Ecology response

From: Jonathan Best <Jonathan.Best@arun.gov.uk>
Sent: 20 December 2024 11:46
To: Planning.Responses <Planning.Responses@arun.gov.uk>
Cc: Harry Chalk <Harry.Chalk@arun.gov.uk>
Subject: K/32/24/PL

Rest Harrow Middle Way East Preston BN16 1SB.

I have reviewed this application with regards to ecology.

Figure 2: Proposed Situation

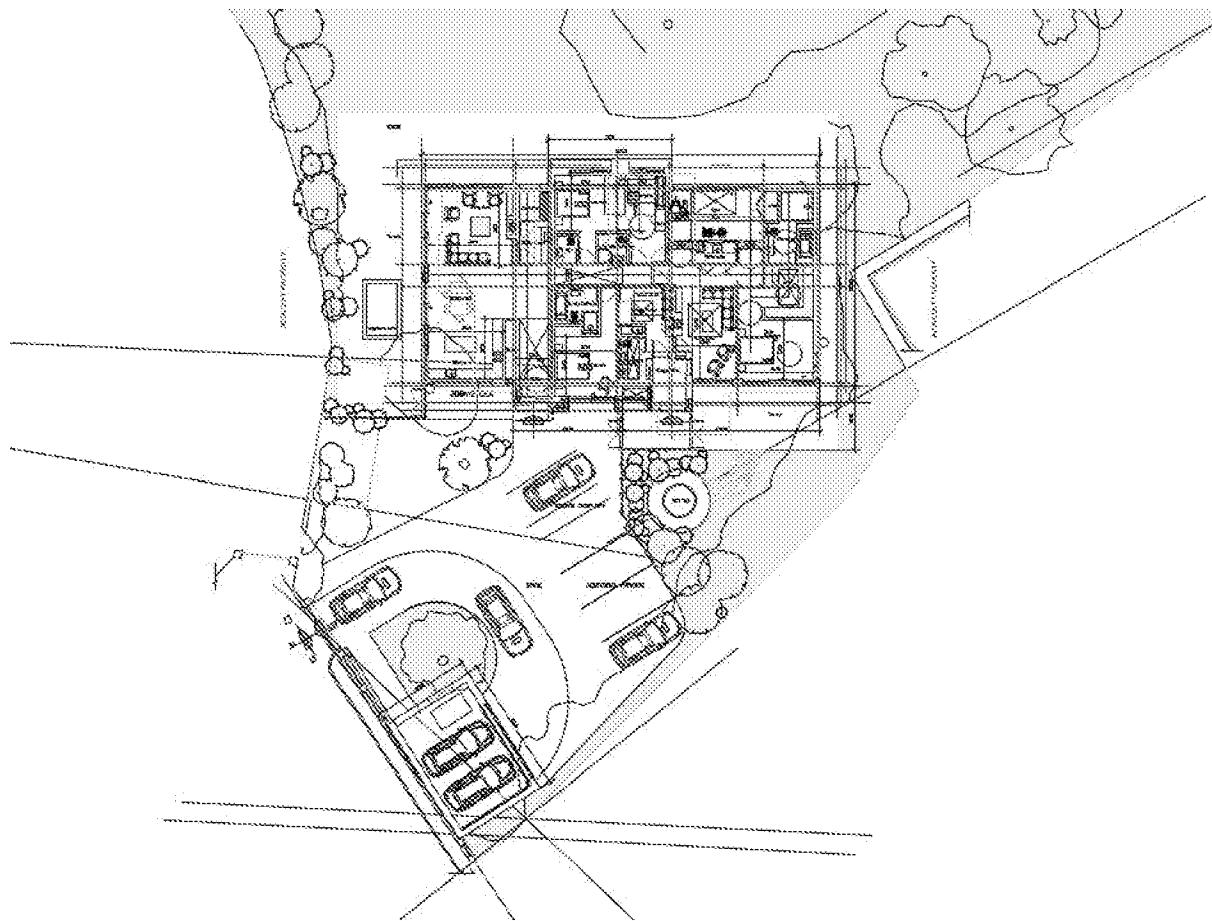
However, the Arboricultural Appraisal Report (08/08/24) by MWA Arboriculture Ltd states that 5 trees 3 tree groups and part of a hedge will be removed.

Removal T1, T2, T3, T4, T5, TG1, SG1, SG3, H1 partial

The impacts of the tree removal have not been assessed and compensatory planting has not been proposed.

I advise that compensatory tree planting is included as part of the biodiversity enhancement.
